A585 Windy Harbour to Skippool Improvement Scheme

TR010035

7.9 Comments on Relevant Representations

COMMENTS ON RELEVANT REPRESENTATIONS

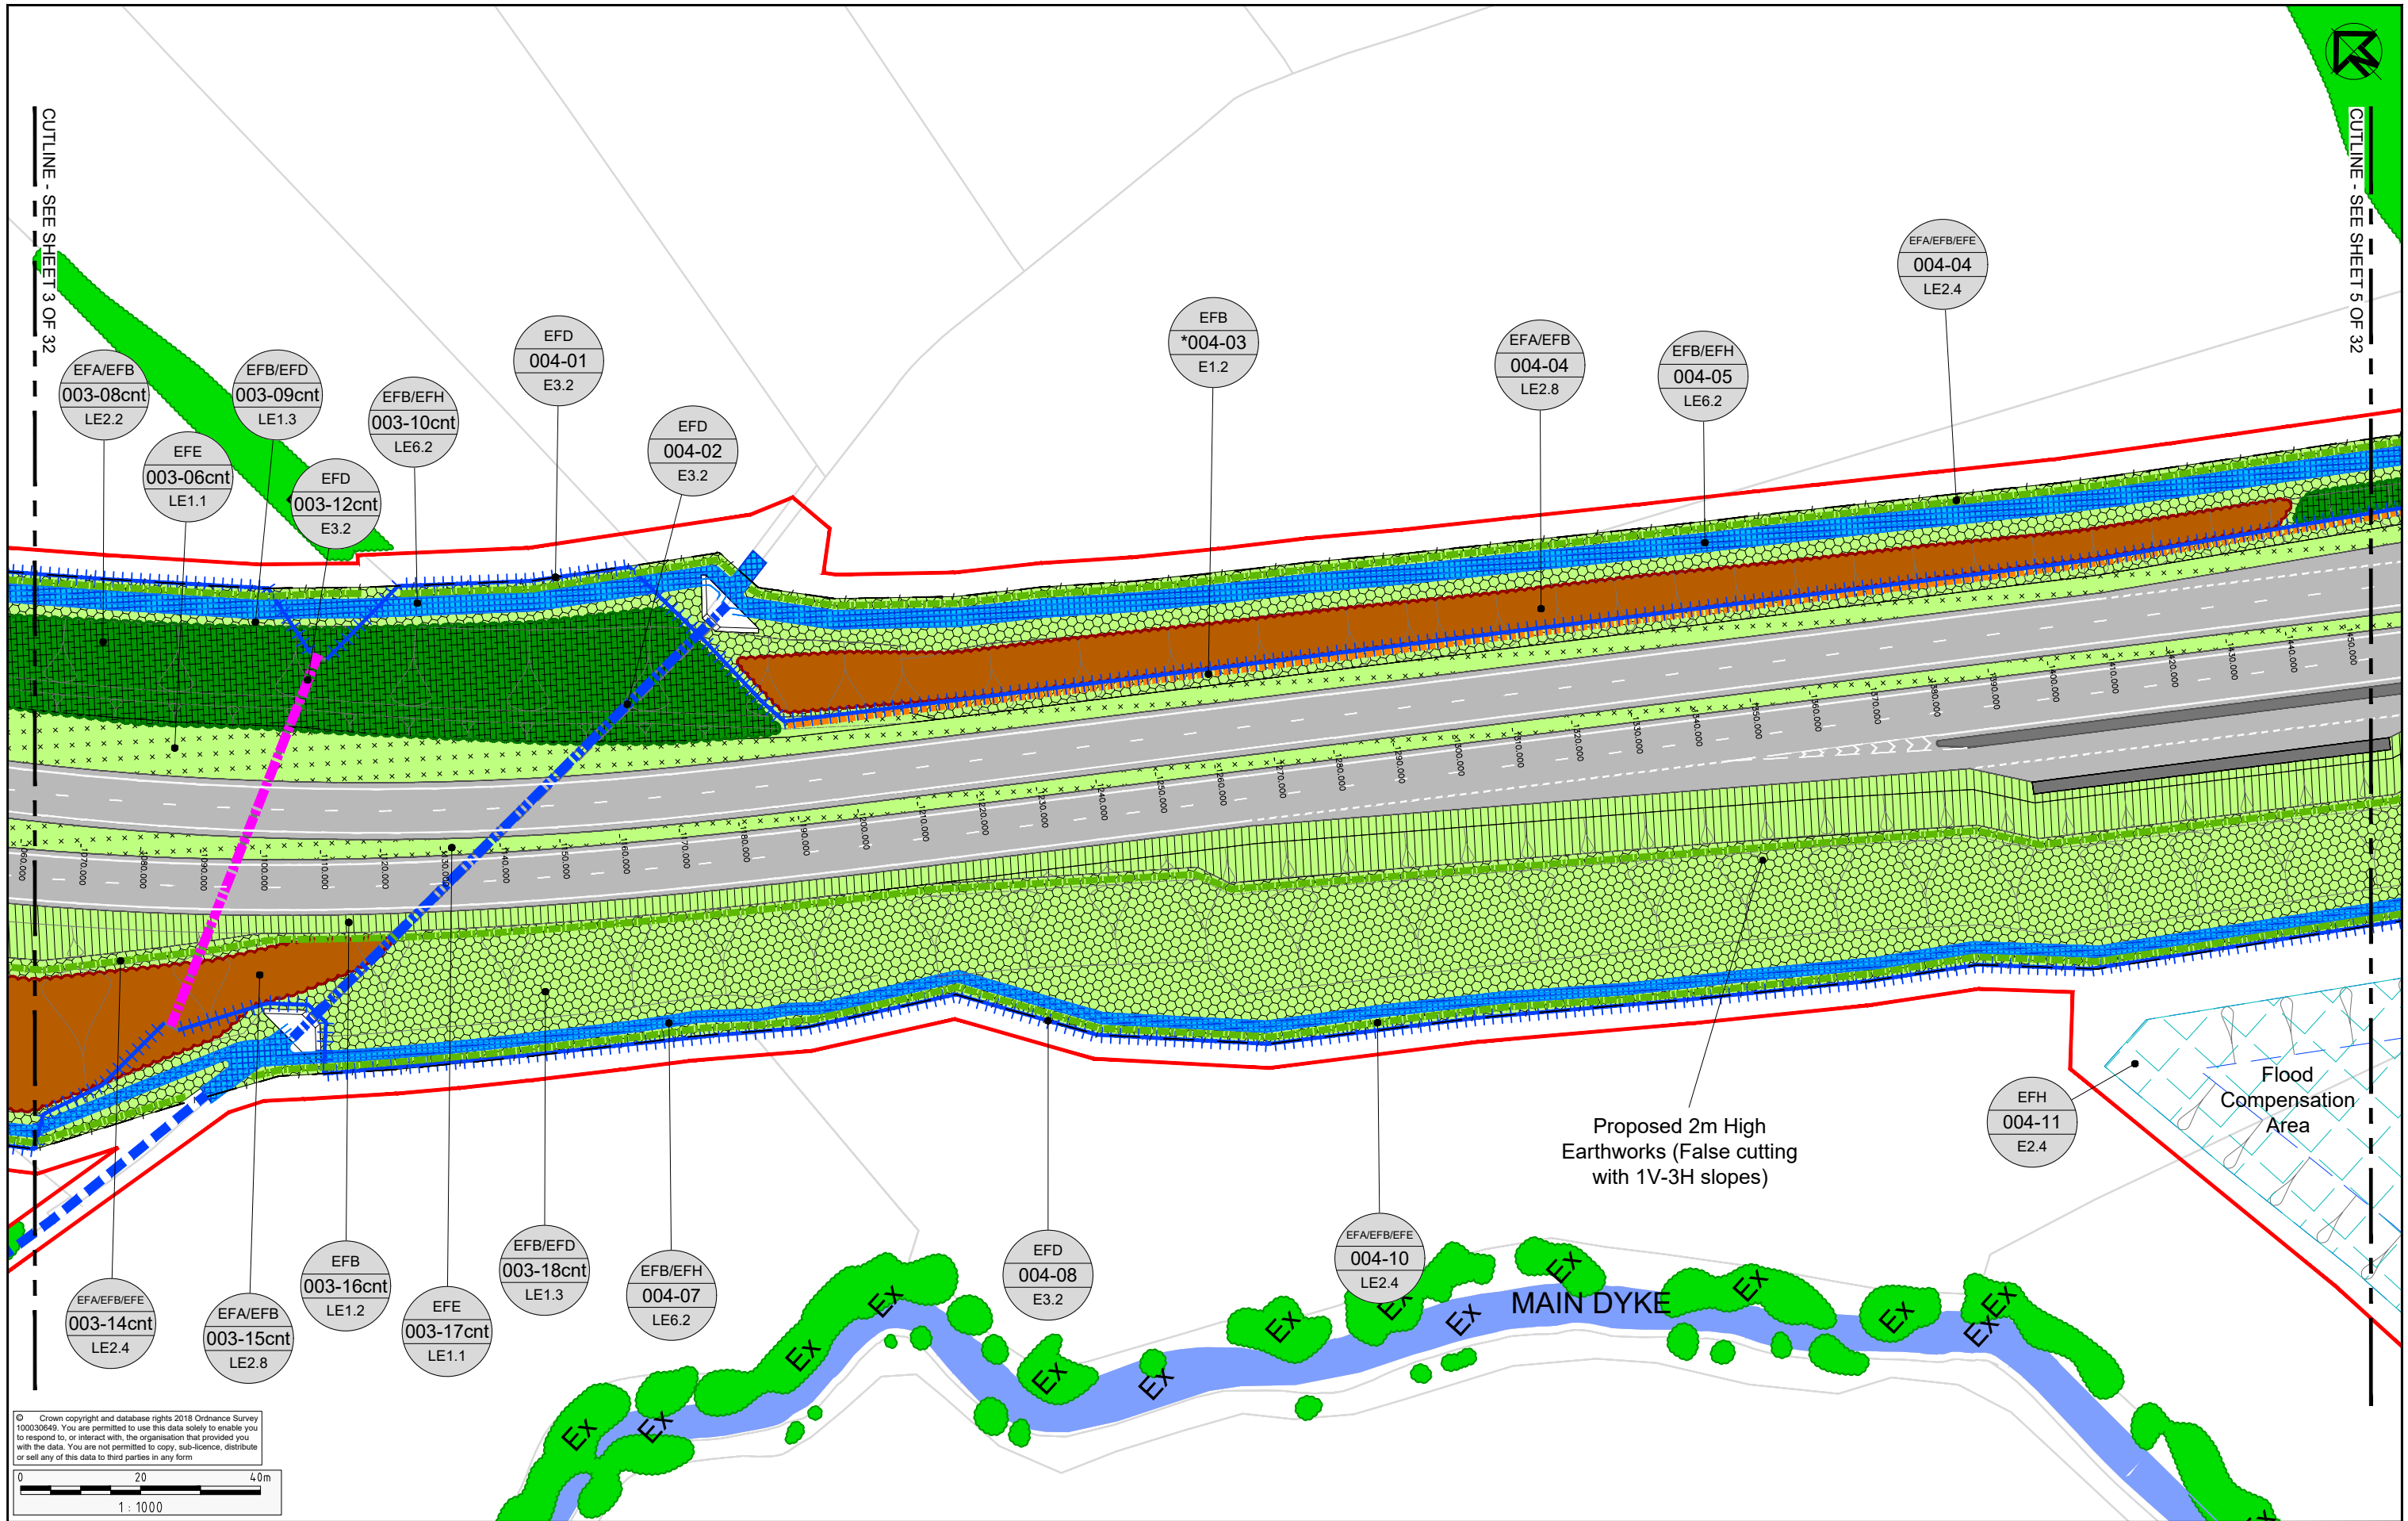
3.7	7. We are concerned about the loss of privacy that will be caused by the creation of the bridges to cross the multitude of roads in the vicinity of our property, these bridges have appeared on the plan without consultation.	<p>At this location where the Scheme is adjacent to the property in question the road alignment is at grade with the existing landform, and no bridges are proposed that would be visible from the property. The only bridge proposed in this vicinity would be the replacement of the existing bridge over Main Dyke (west of the Skippool Service station) with a new bridge for the proposed dual carriageway at the same location. This has not changed since the start of development of the Scheme and was initially indicated in the non-statutory consultation in 2016.</p> <p>In addition, a 2m high noise barrier is proposed between the road and property which is further flanked by woodland planting which would be planted as an enhanced size stock providing additional screening at opening year. Refer to the Environmental Masterplan (document reference TR010035/APP/6.19) Sheet 3 for planting and noise mitigation.</p>
